# PLN-PUDSP21005-R5-PUDSP.pdf Markup Summary

**Subject:** Architect  
**Page Label:** [1] WB PUDSP 10.7.22-Cover  
**Author:** Ryan Howser  
**Date:** 11/8/2022 12:39:02 PM  
**Status:**  
**Color:** ■  
**Layer:**  
**Space:**

SHEET TITLE: **WEST AREA DEVELOPMENT PLAN**

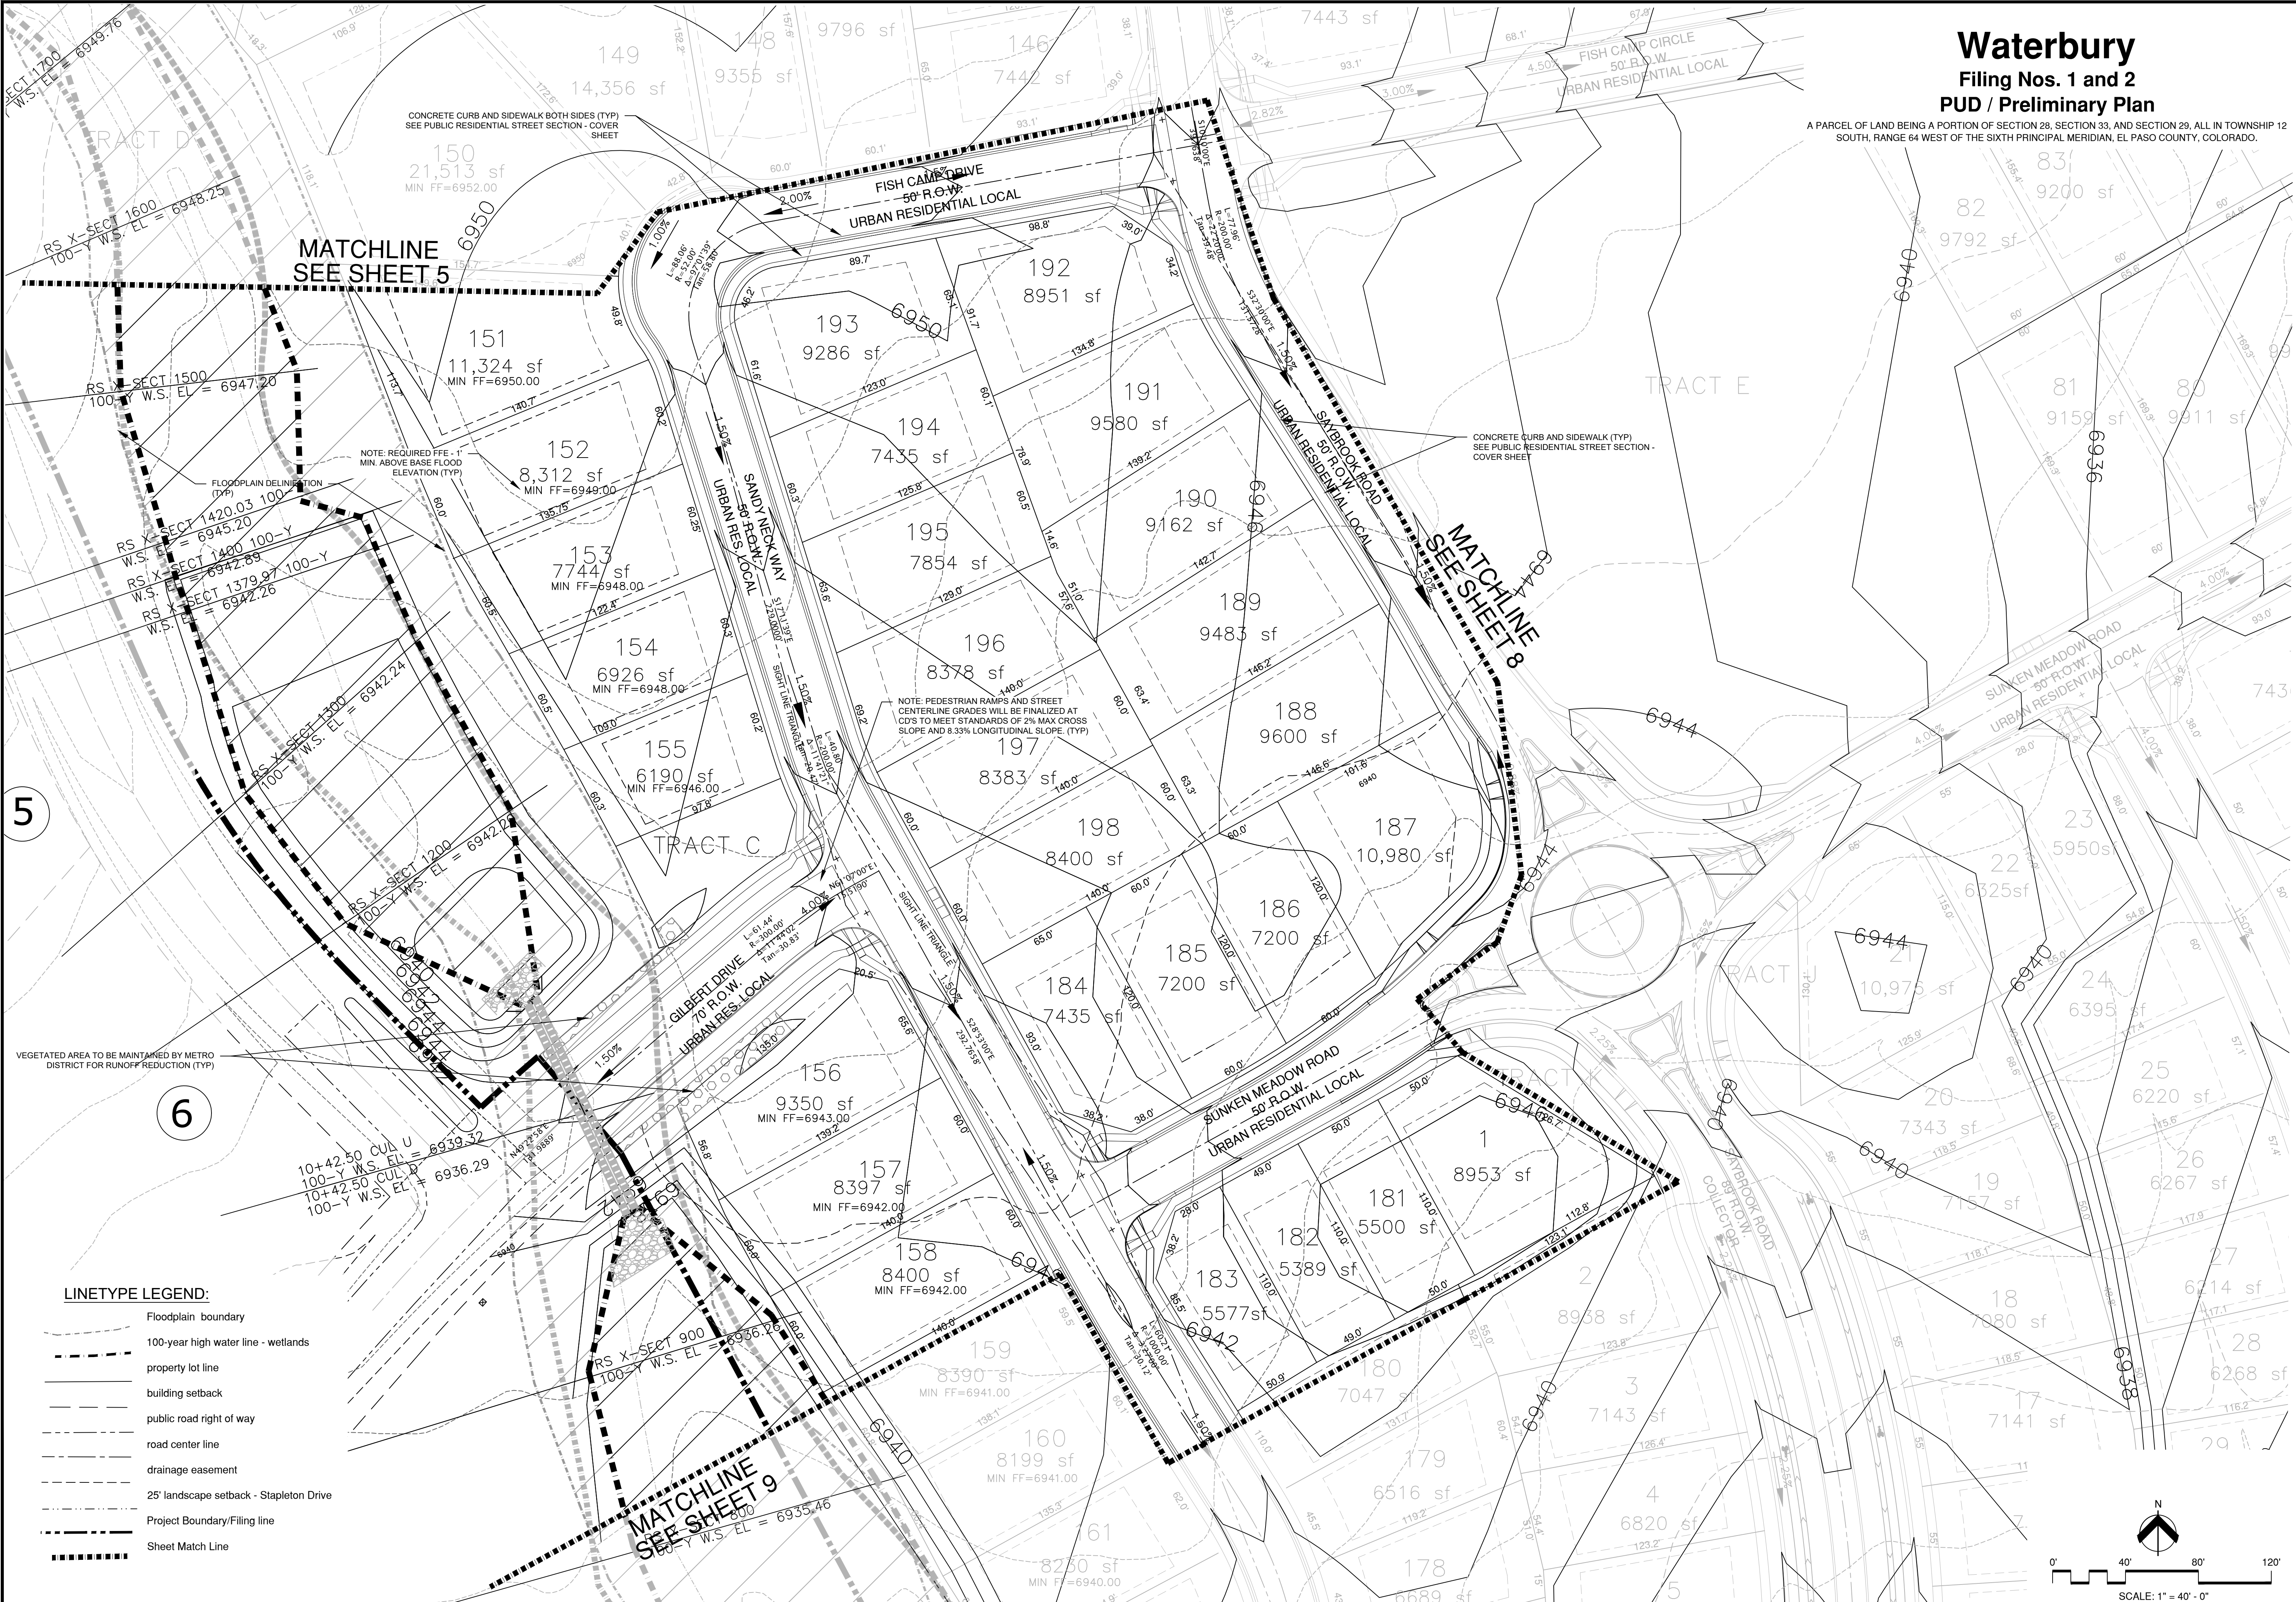
Show culverts  
**added**

adjust text onto sheet

corrected

SHEET TITLE:
PUD/PRELIMINARY PLAN

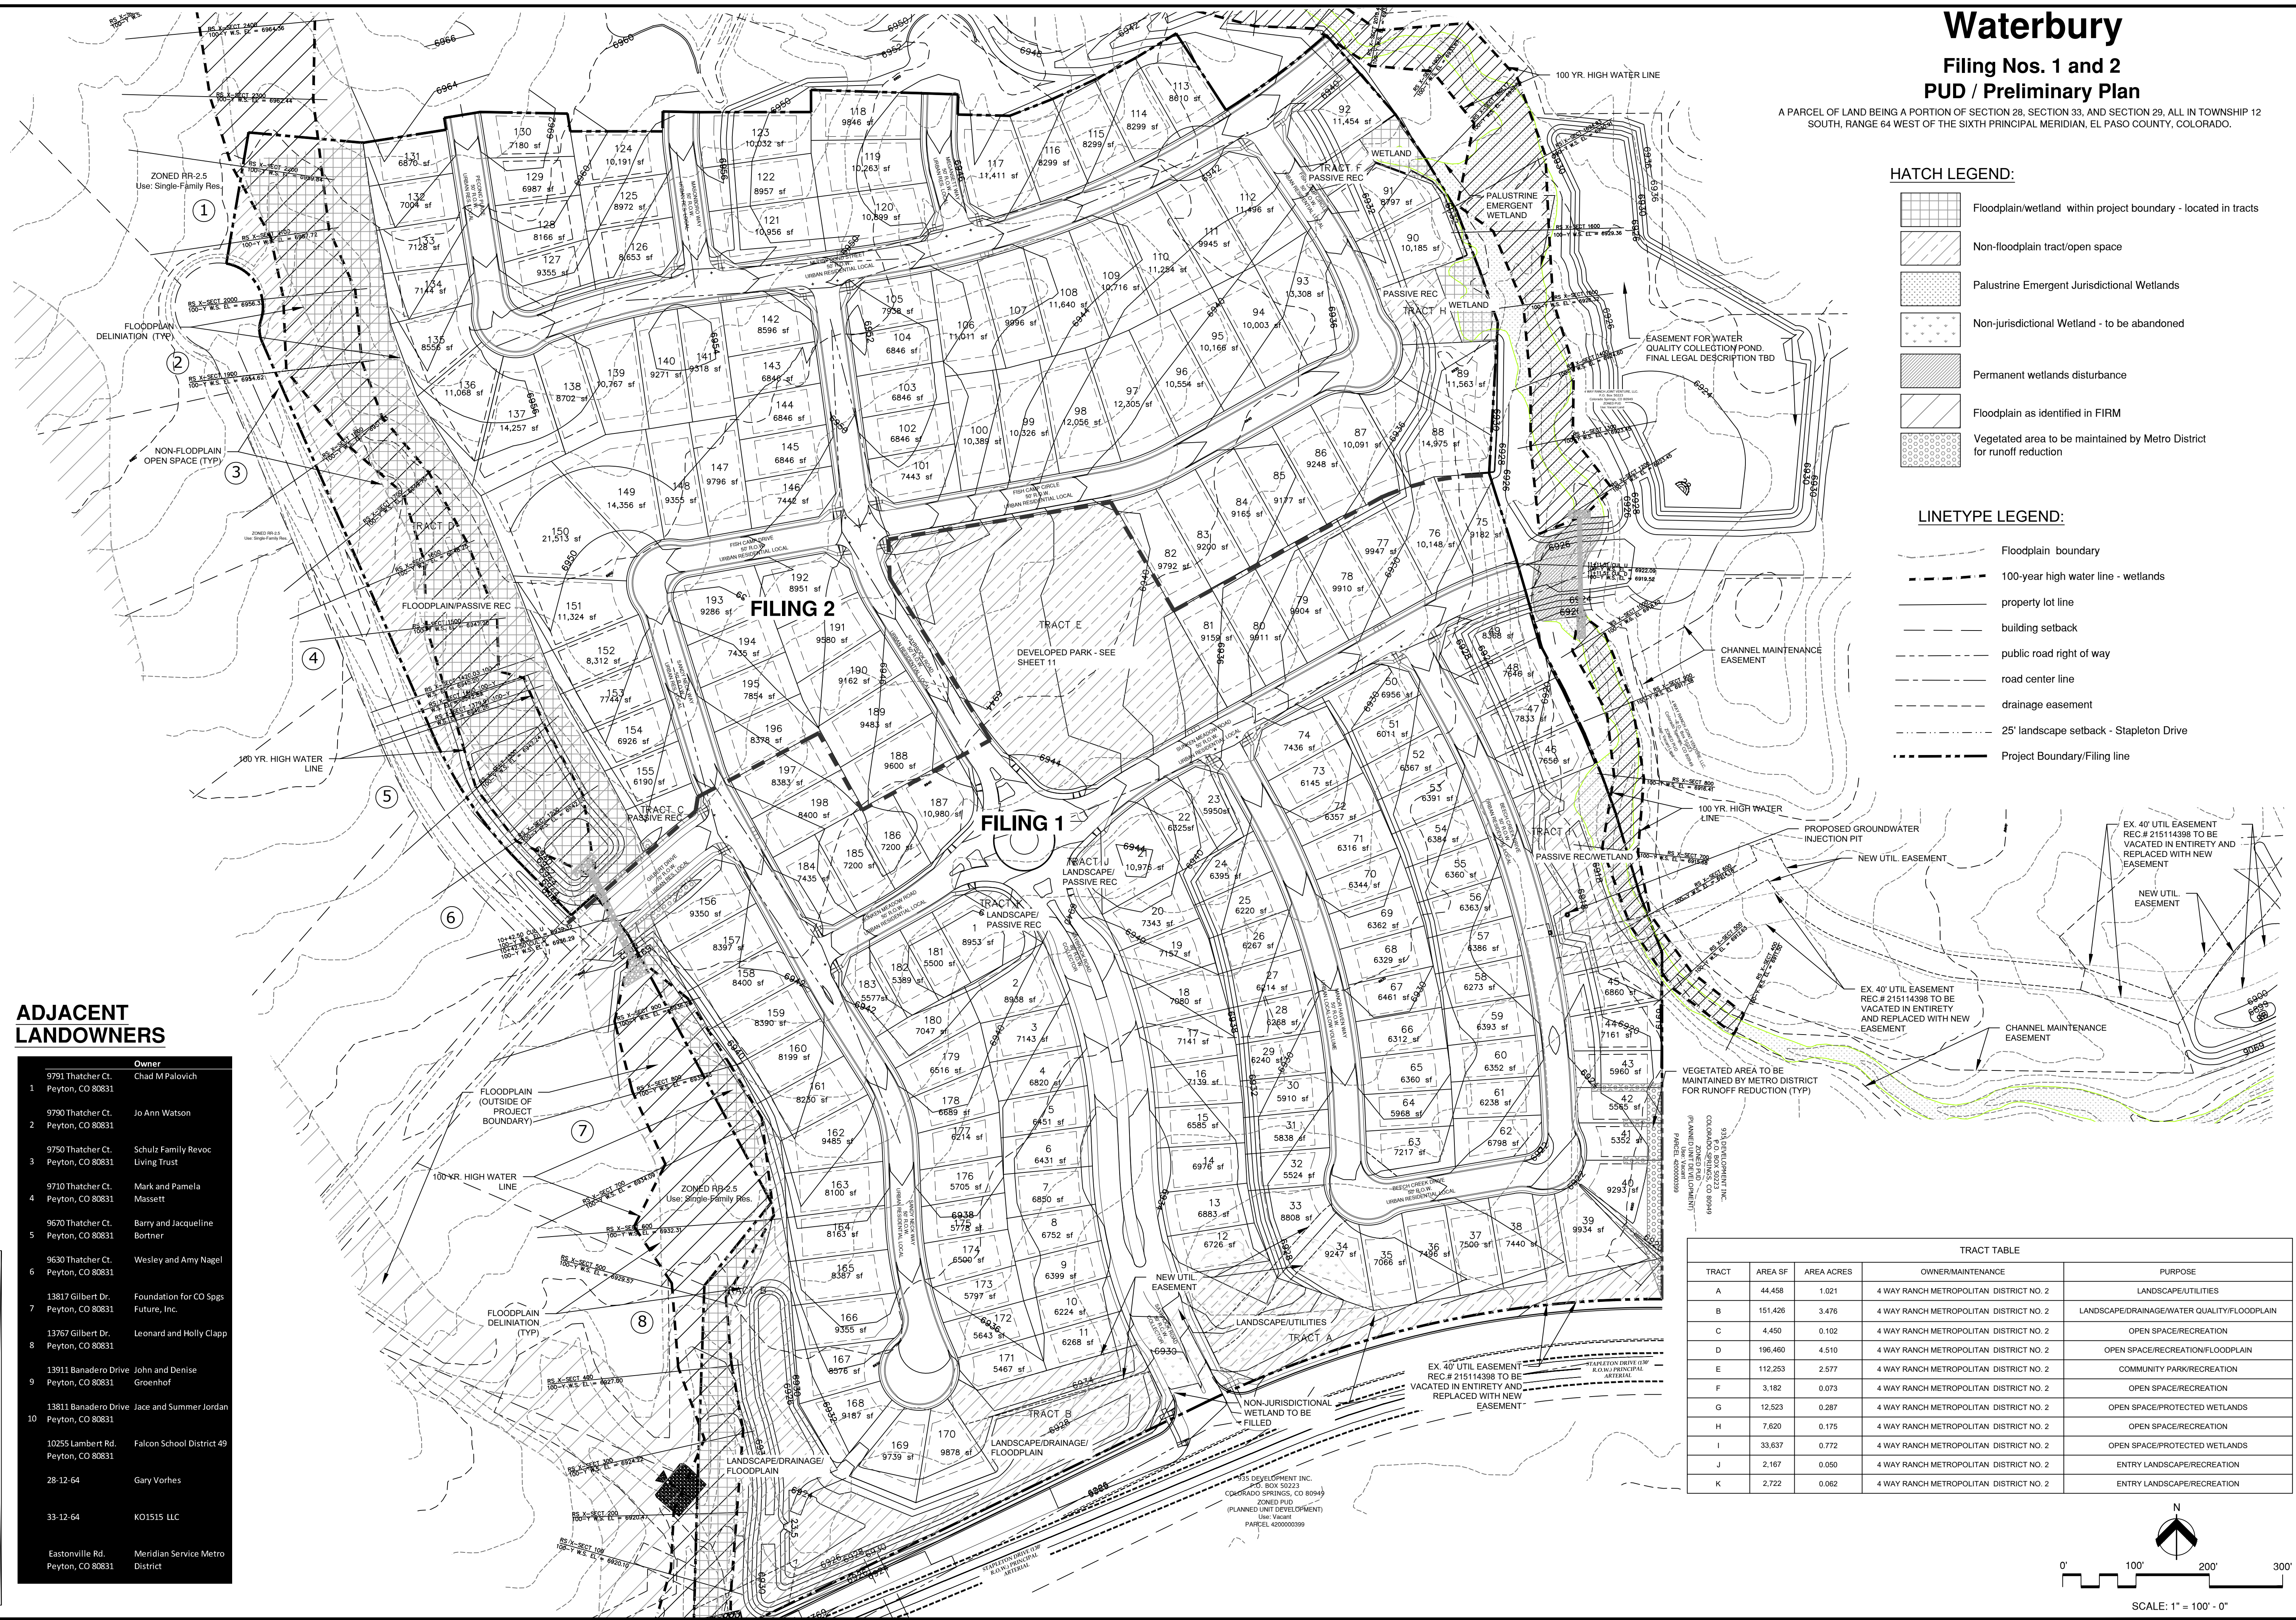
The easement shown doesn't appear to match this document  
**both old and new now shown and labeled**

Add hatching to legend  
**corrected**

Replace existing contours  
**corrected**

Show culverts  
**added**

SHEET TITLE: EAST AREA DEVELOPMENT PLAN

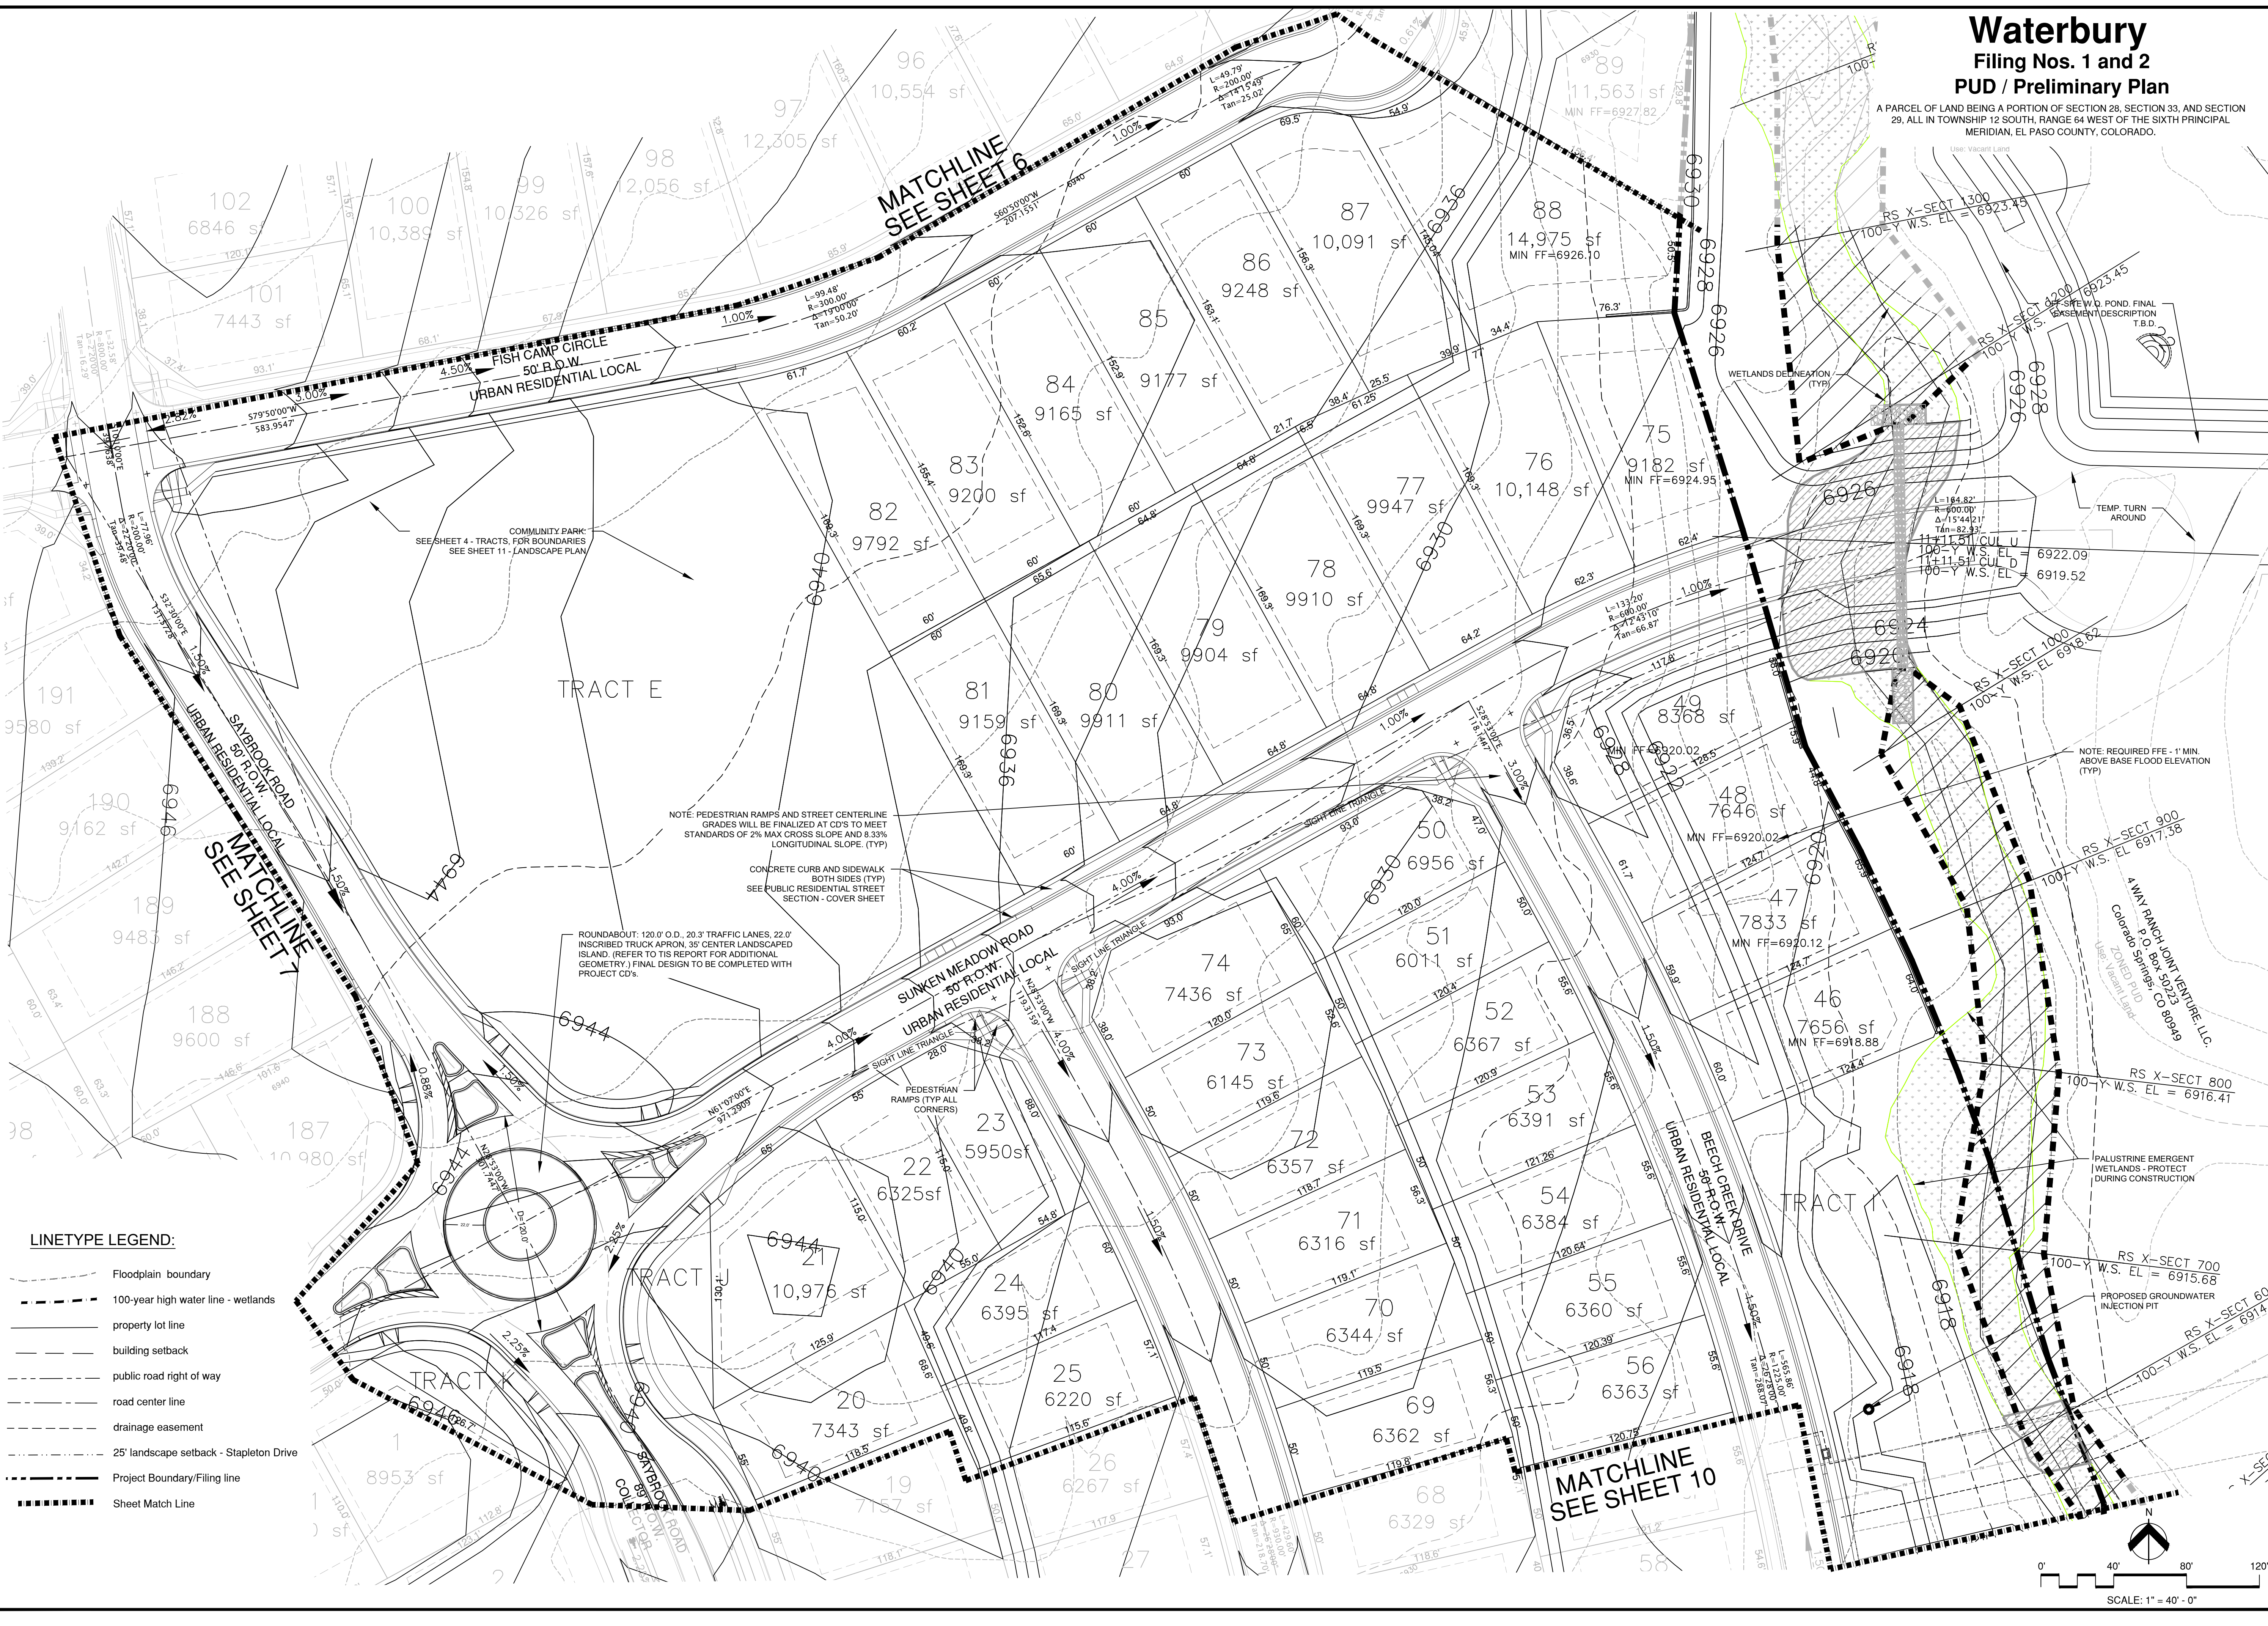
Show culverts  
**added**
